KIRKLEES METROPOLITAN COUNCIL INVESTMENT & REGENERATION SERVICE

DELEGATED DECISION TO DETERMINE PLANNING APPLICATIONS

Reference No:	2023/62/93675/W
Site Address:	4, Wholestone Gate, Scapegoat Hill, Huddersfield, HD7 4PP
Description:	Erection of single storey rear extension with terrace
Recommending Officer:	Molly Storer

HOUSEHOLDER DELEGATED REPORT

1 PROPOSED EAST ELEVATION
1 : 100

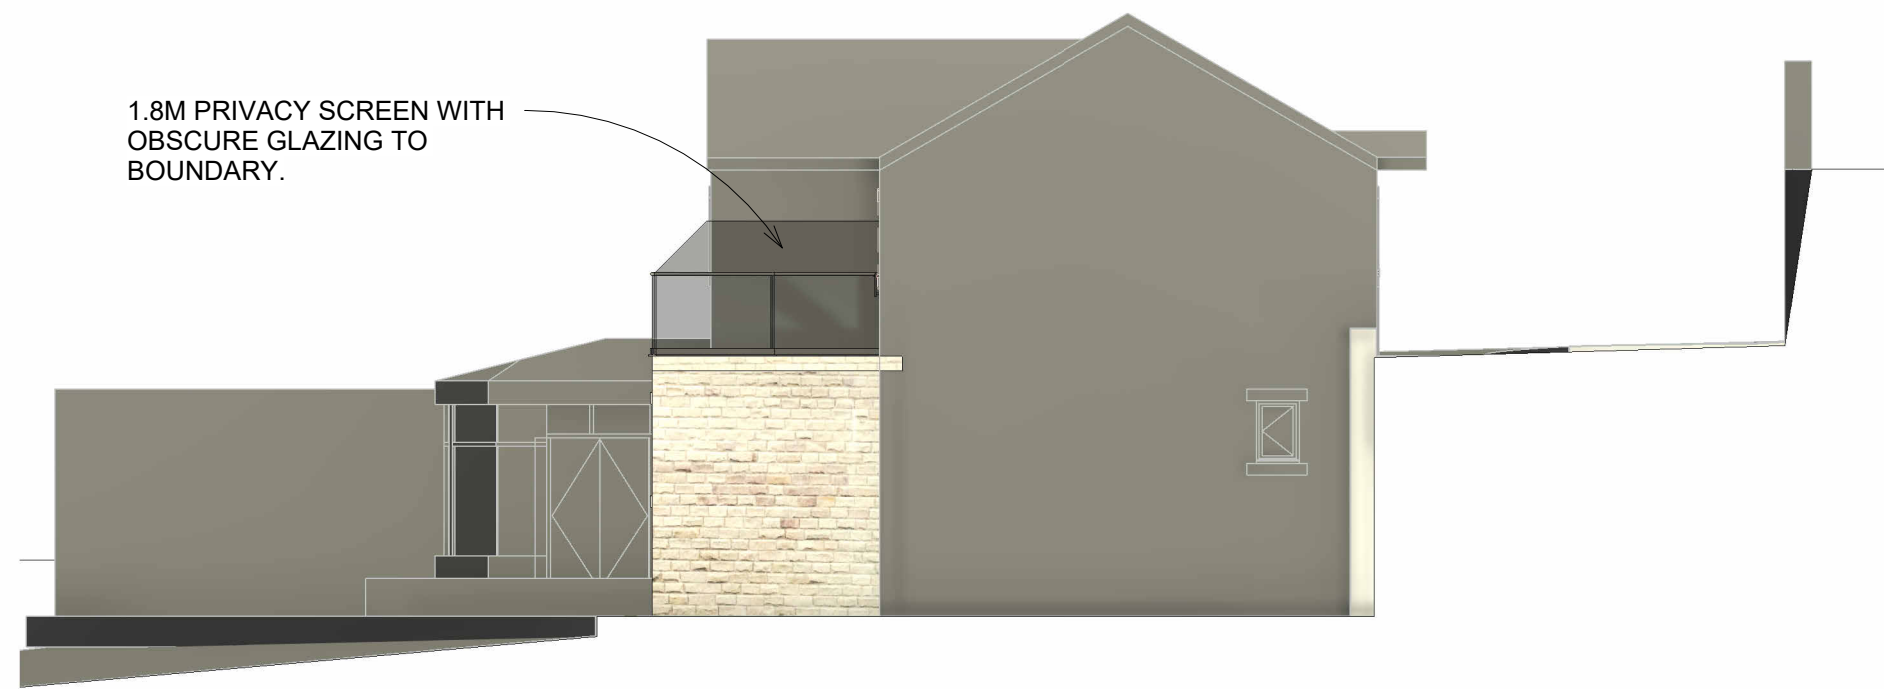
- Secured with a 1m high glazed balustrade to the south and west boundaries
- 7.3m in length
- Have a ~1.8m privacy screen with obscure glazing to the eastern boundary
- Have a 3m projection from lounge
- Have a 1.5m projection from kitchen/dining room

Relevant key design principle (KDP) of the SPD, Policy in the Kirklees Local Plan and the NPPF	Further comments	✓ / X / N/A
Impact on privacy of neighbours (to sides, rear and front)	• KDP 3 & 4 of the SPD • Policy LP24 Design (d) (iv) • Chapter 12 of the NPPF	In regard to No.2, this property will be screened by the host property's existing conservatory which is on a higher ground level than the proposed extension and also has a significant separation distance of ~16m from the development. Although there is no privacy screen along this elevation of the terrace, given the separation and intervening structures, no material loss of amenity would occur to no. 2. A privacy screen of adequate height and specification is proposed to no. 6. In addition, there are no openings within the side elevations of the rear extension increasing privacy to neighbours.	✓
Impact on light and outlook of neighbours (to sides, rear and front)	• KDP 4, 5, 6 of the SPD • Policy LP24 Design (b) • Chapter 12 of the NPPF	Due to the limited scale of the extension, the separation distance and due to the existing development between the host property and No.2 this property will not be significantly impacted in terms of overshadowing. Due to the orientation of the properties the garden of No.6 may experience some limited shadowing in the late evening of the summer months however due a gap of ~5m between the proposed	✓

4. The 1.8m high obscure glazed privacy screen as shown on the eastern boundary of the roof terrace hereby approved on elevation plan no. Drawing No. 288_(100) 02 shall be installed to the east elevation of the raised terrace area as shown on that plan, before the raised terrace area is first brought into use. The 1.8m high obscure glazed privacy screen shall thereafter be retained in accordance with the approved plans.

4 PROPOSED FIRST FLOOR PLAN
1 : 100

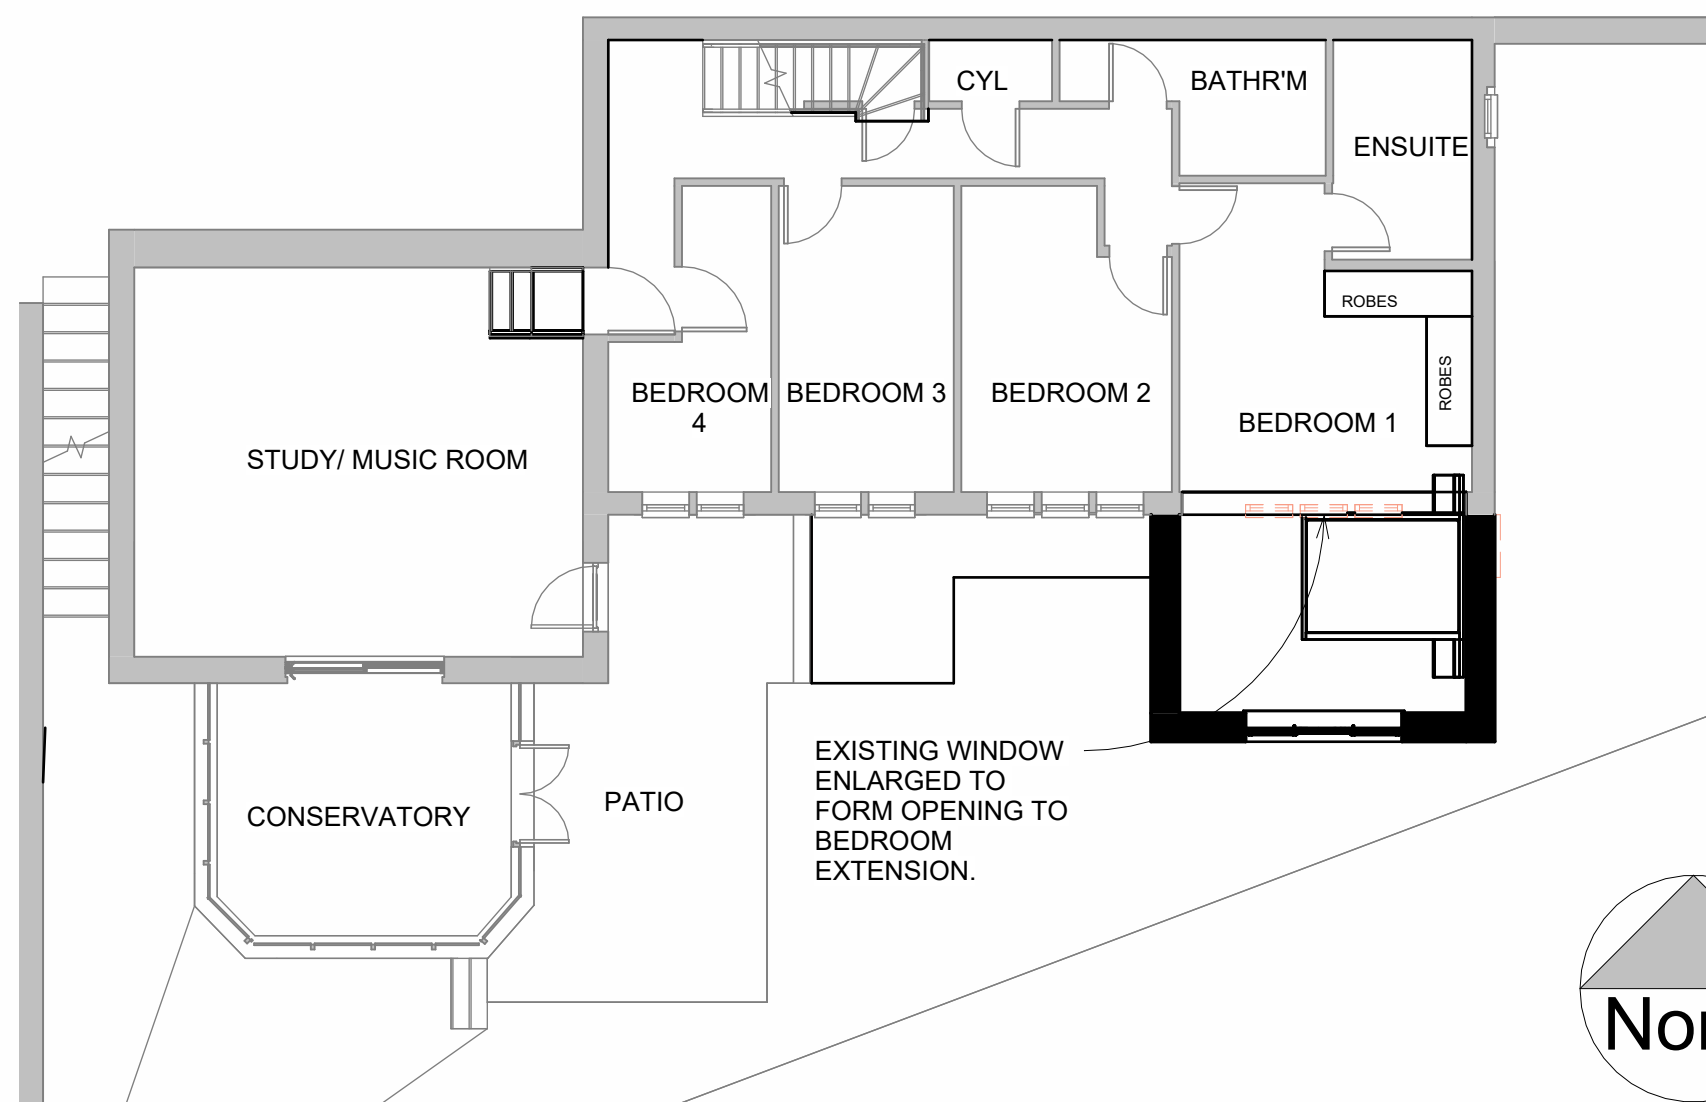
Balconies should not:	<u>Yes - COMPLY</u>	<u>No - JUSTIFY</u>
Balconies and roof terraces on existing buildings should not negatively affect neighbouring properties or alter the local character of the area.	Yes – the design uses modern glazing to its balustrade enabling a visually permeable and low impact addition to the host's single-storey rear extension. The addition of a privacy screen has been positioned away from the shared boundary so as to avoid affecting neighbouring property. Balconies can be seen as a feature of the locality and therefore this would not
